The Coal
Authority

19 February 2024

Re: Planning application 2023/62/93704/E

**Erection of 10 dwellings and associated works at Land Northwest of Urban Terrace,
Denby Lane, Grange Moor, Huddersfield, WF4 4EB**

1 Proposed Site Layout

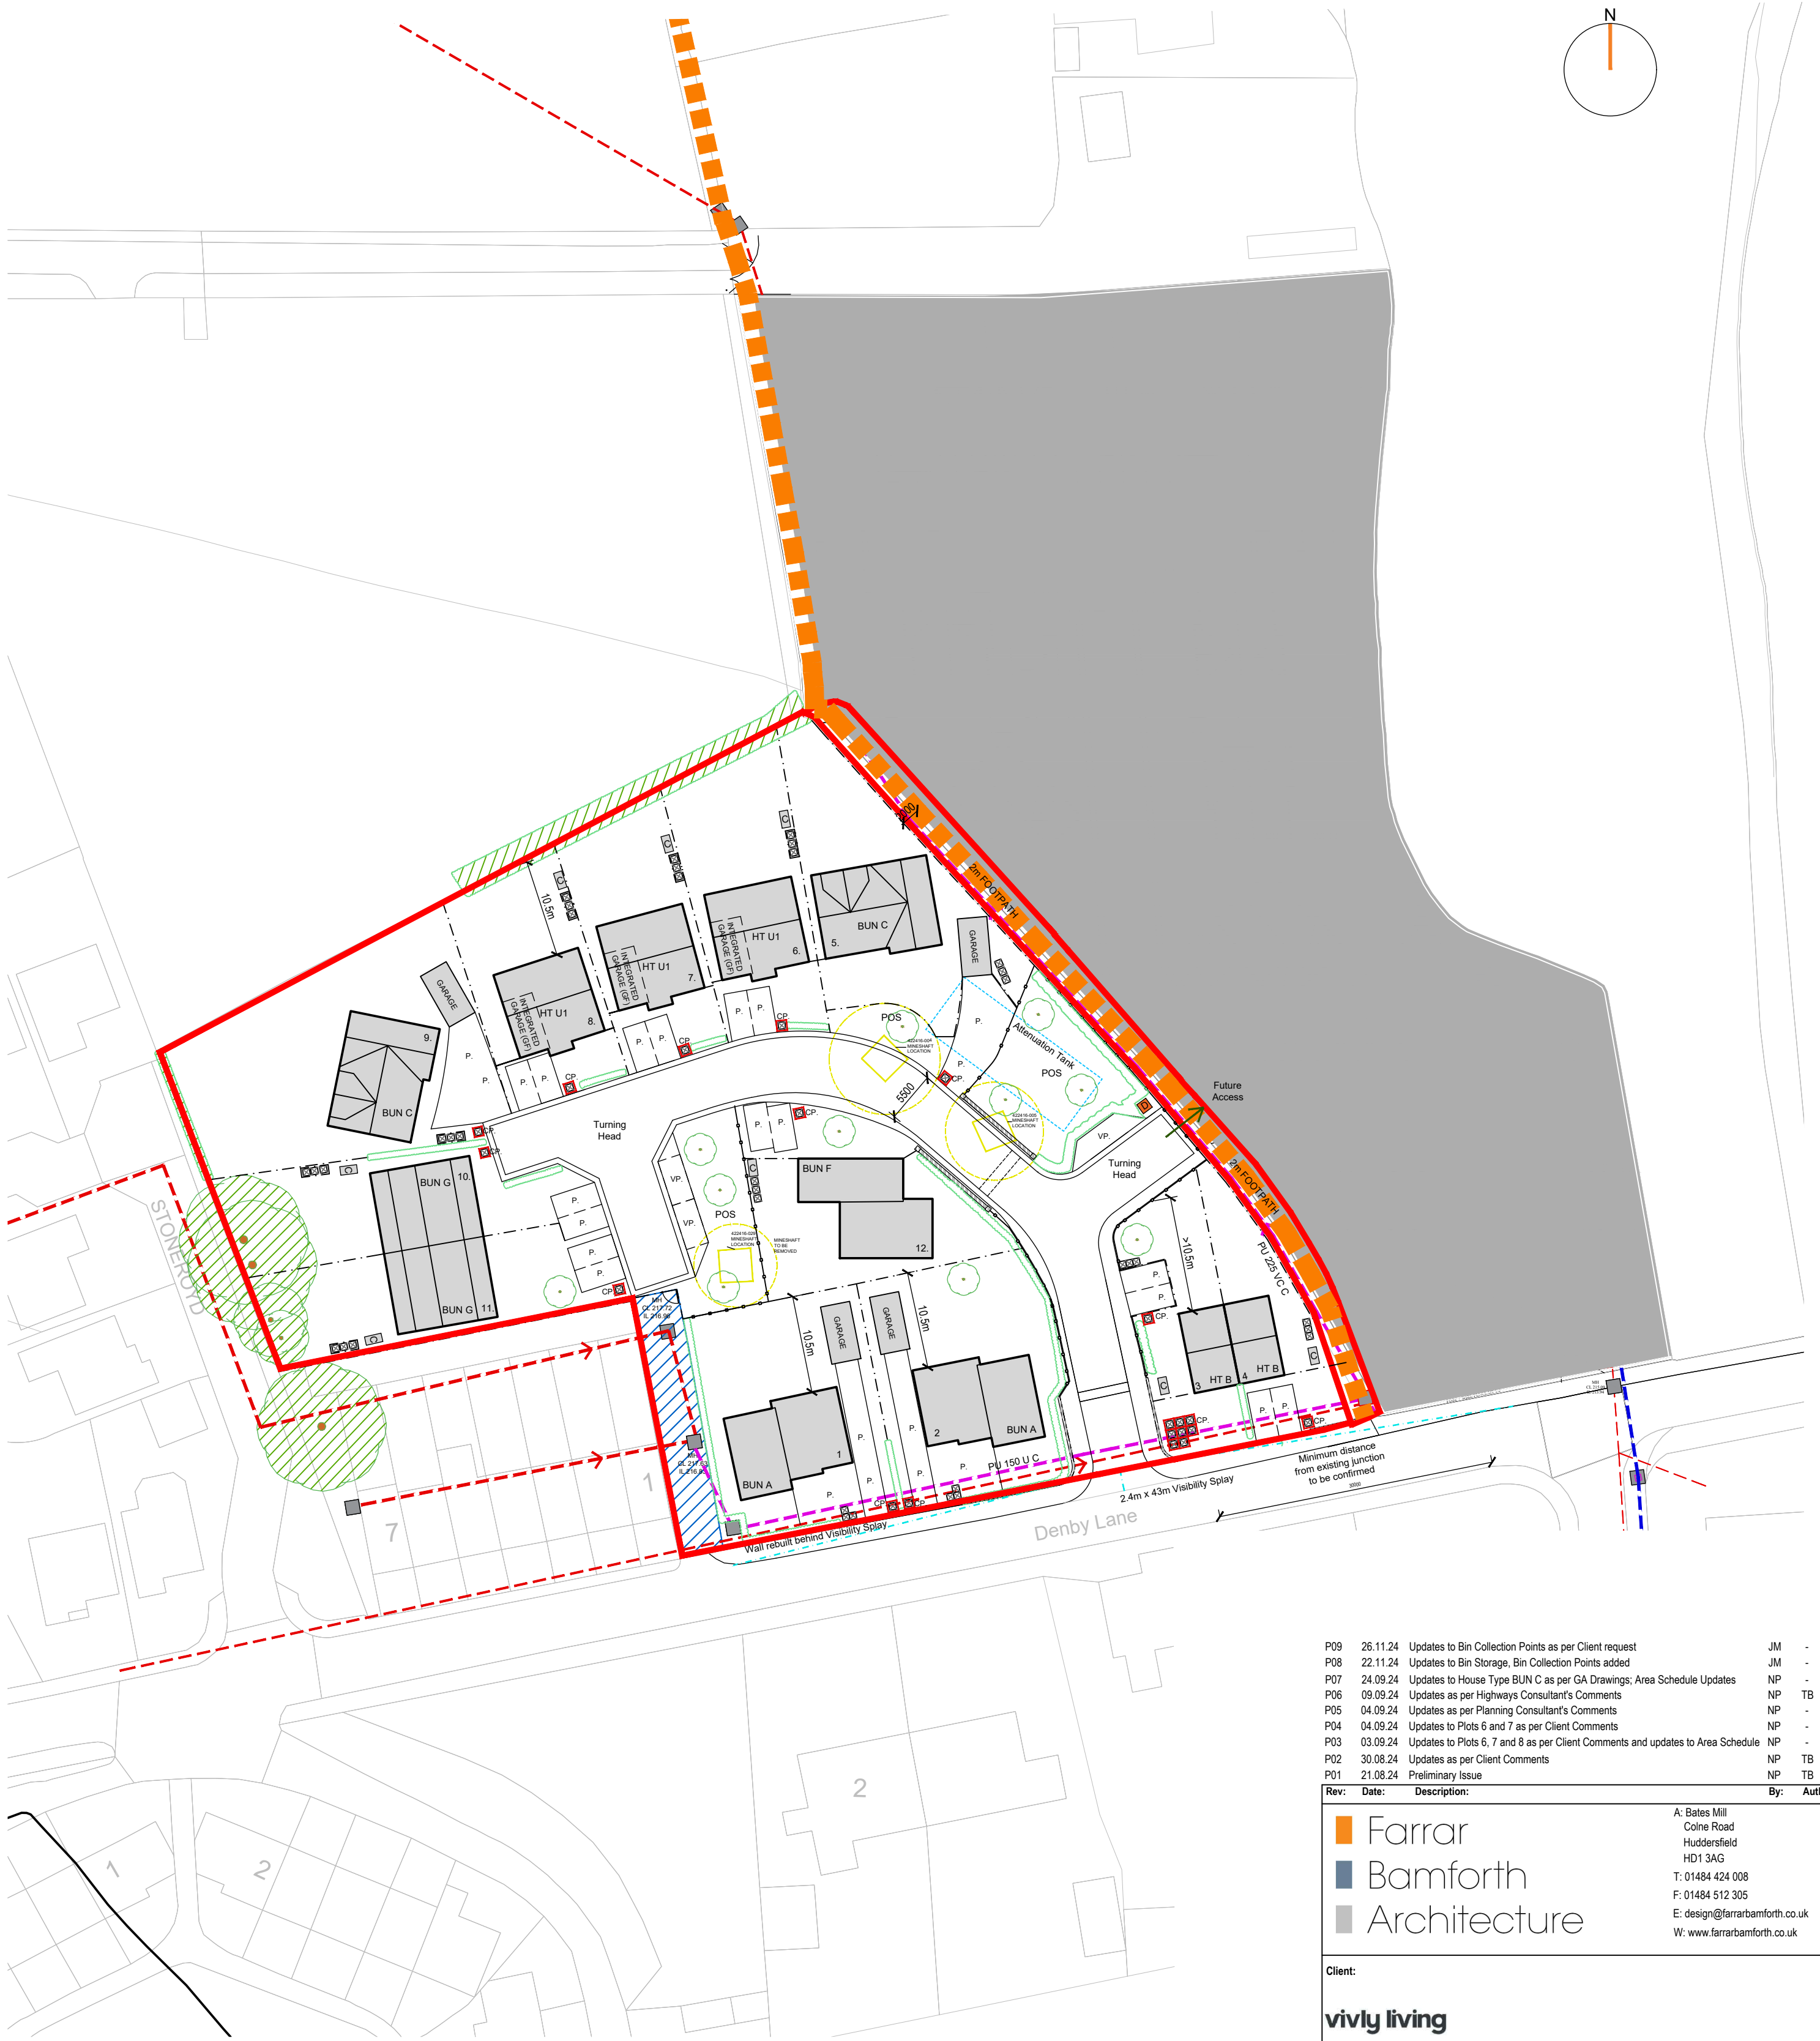
We are pleased to note that the shaft positions and their calculated zones of influence are shown on the proposed Site Layout (Drawing No 22D26-FBA-ZZ-XX-DR-A-0708 Rev. P11). This plan demonstrates that the proposed dwellings have been sited in a manner which avoids the shafts and their associated zones of influence.
